2023/0386

2 Pollitt Street, Old Town, Barnsley, S75 1DJ

Demolition of existing garages and erection of a replacement block of 4no garages.

PROPOSED  
FRONT ELEVATION  
SCALE 1:100

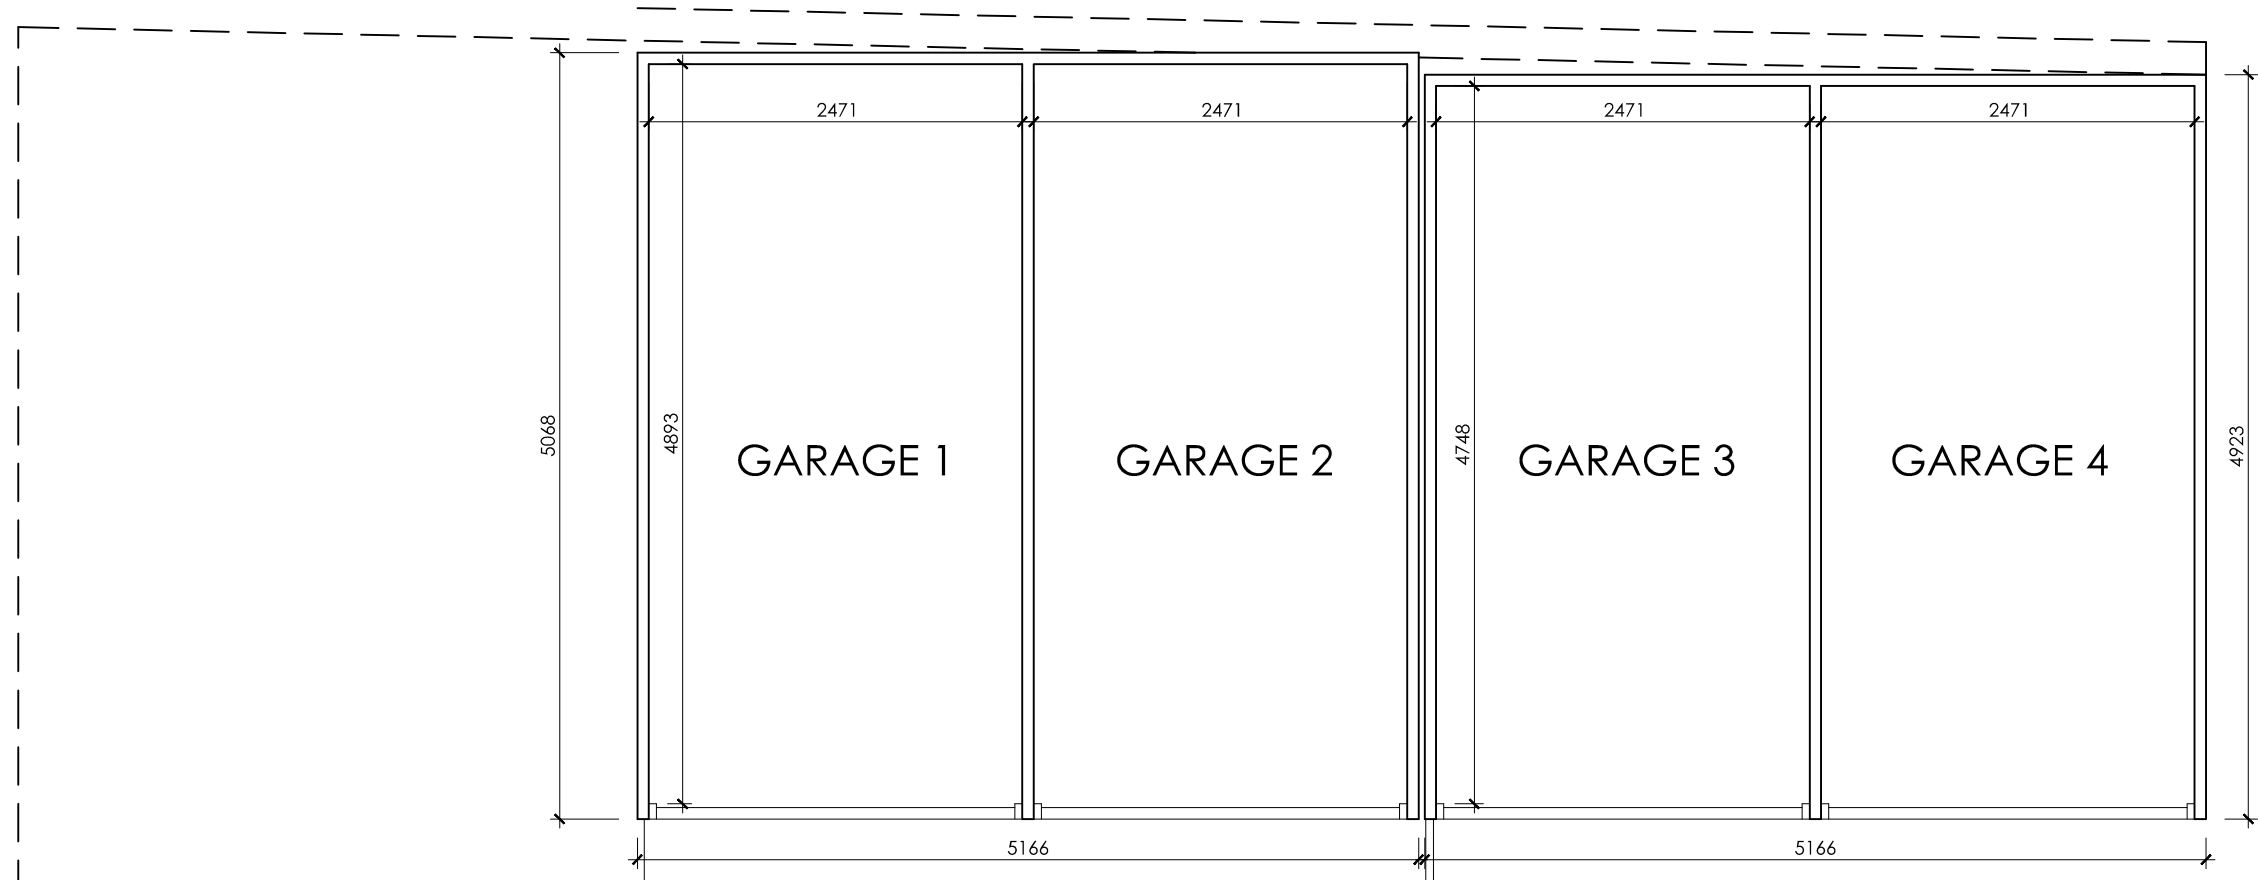
The proposed replacement garages would adopt a similar construction of prefabricated pebble dash concrete and use flat roofs. Whilst the use of prefabricated pebble dash is not considered to be the best choice for the setting of the garages, and the use of flat roofs considered to be an inferior form of design and method of construction, the proposals are not considered to significantly detract from the character of the street scene nor create additional harm to the setting of the Conservation Area beyond existing impacts. Additionally, improvements to the garage doors and roof materials to use black vertical GRP doors and slate-coloured rubber bond roofs have been agreed in-line with comments received from the Conservation Officer and are considered sufficient to mitigate some of the impact regarding visual amenity and harm to the setting of the Conservation Area.

In this instance, the proposed replacement garages would maintain the footprint and massing of the existing garages with a slightly increased height of approximately 0.2 metres; as such, the replacement garages are not considered to be an overly overbearing structure that would significantly increase overshadowing and overlooking or reduce outlook beyond existing impacts that are experienced and tolerated.

PROPOSED  
GROUND FLOOR PLAN  
SCALE 1:50

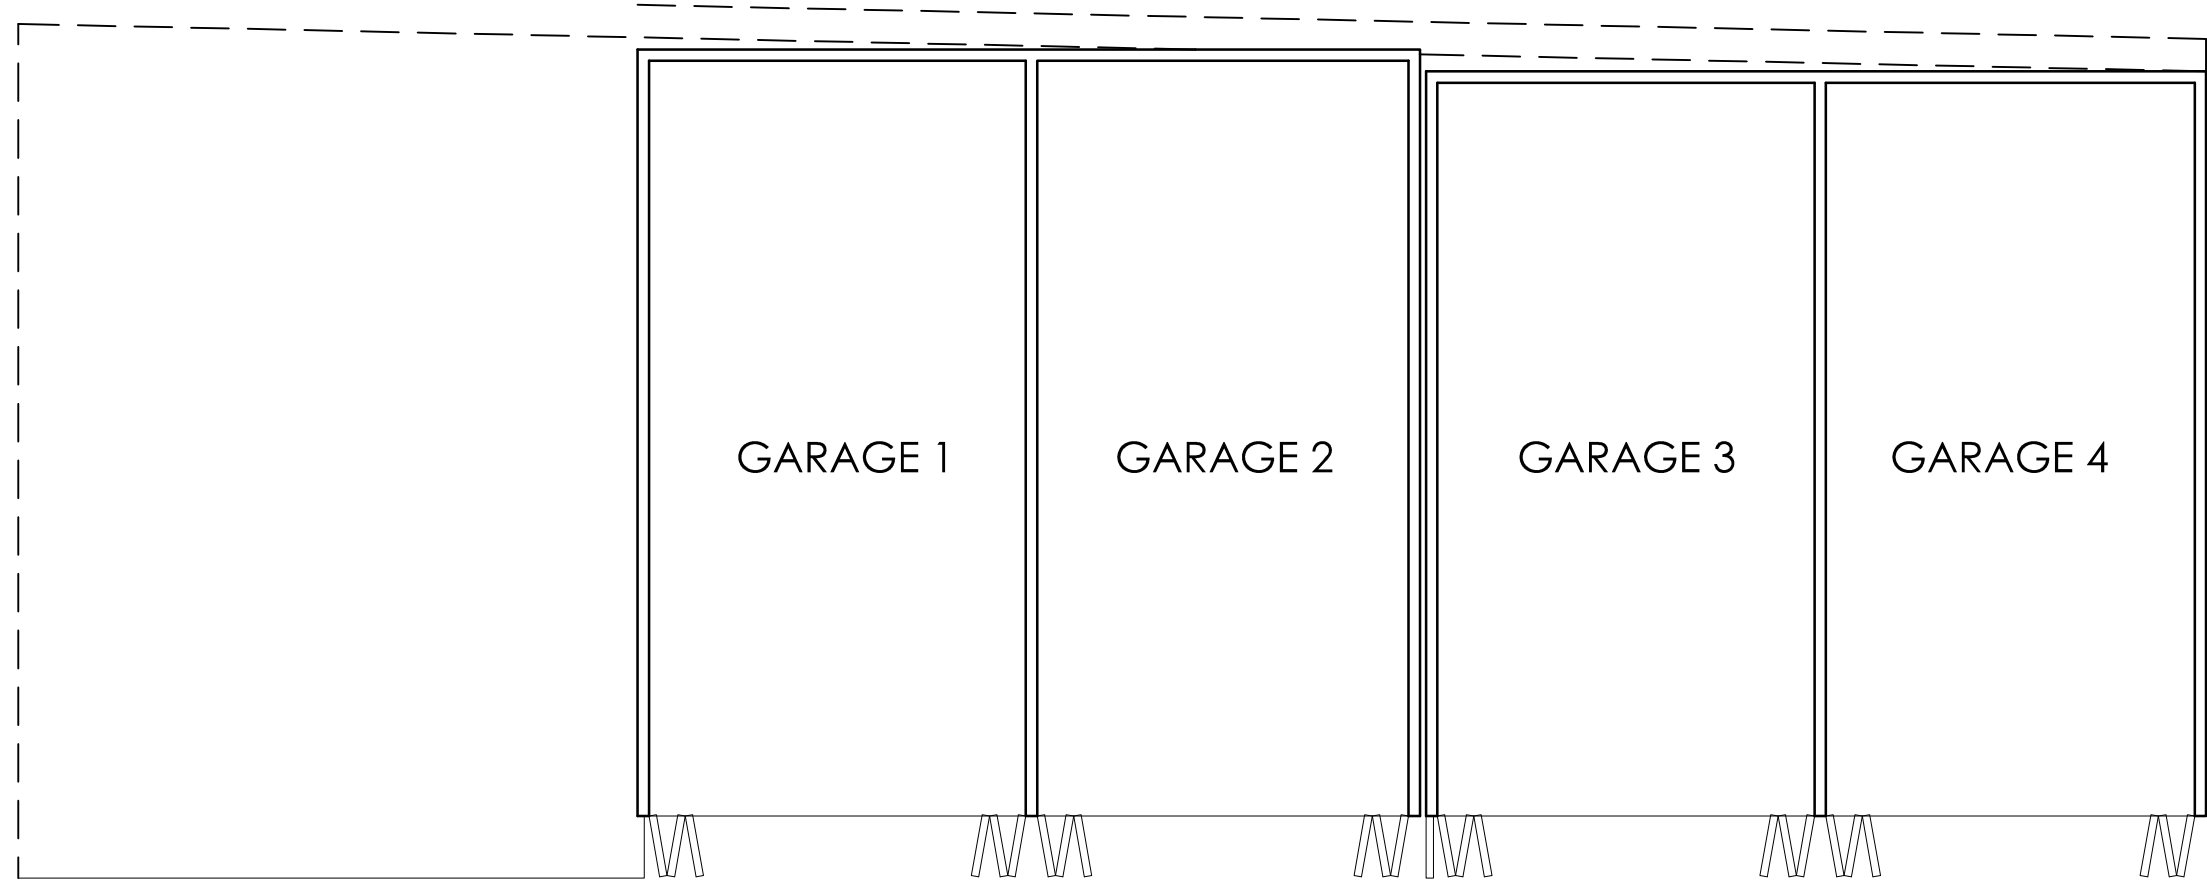
Highways were consulted and they provided comments identifying that the internal spaces created would not comply with modern standards set out in the South Yorkshire Design Guide. Whilst it is acknowledged that the proposed garages may not be suitable to store all sizes of modern car, it is recognised that the proposals are a like-for-like replacement and increasing the minimum dimensions to 3 metres by 6 metres to meet modern standards may not be feasible in this instance.

The standard size of a non-residential parking space is 5 metres in length and 2.5 metres wide. Internally, the proposed garages would achieve dimensions relatively close to this; as such, it is accepted that the garages could be used to store or park some smaller vehicles.
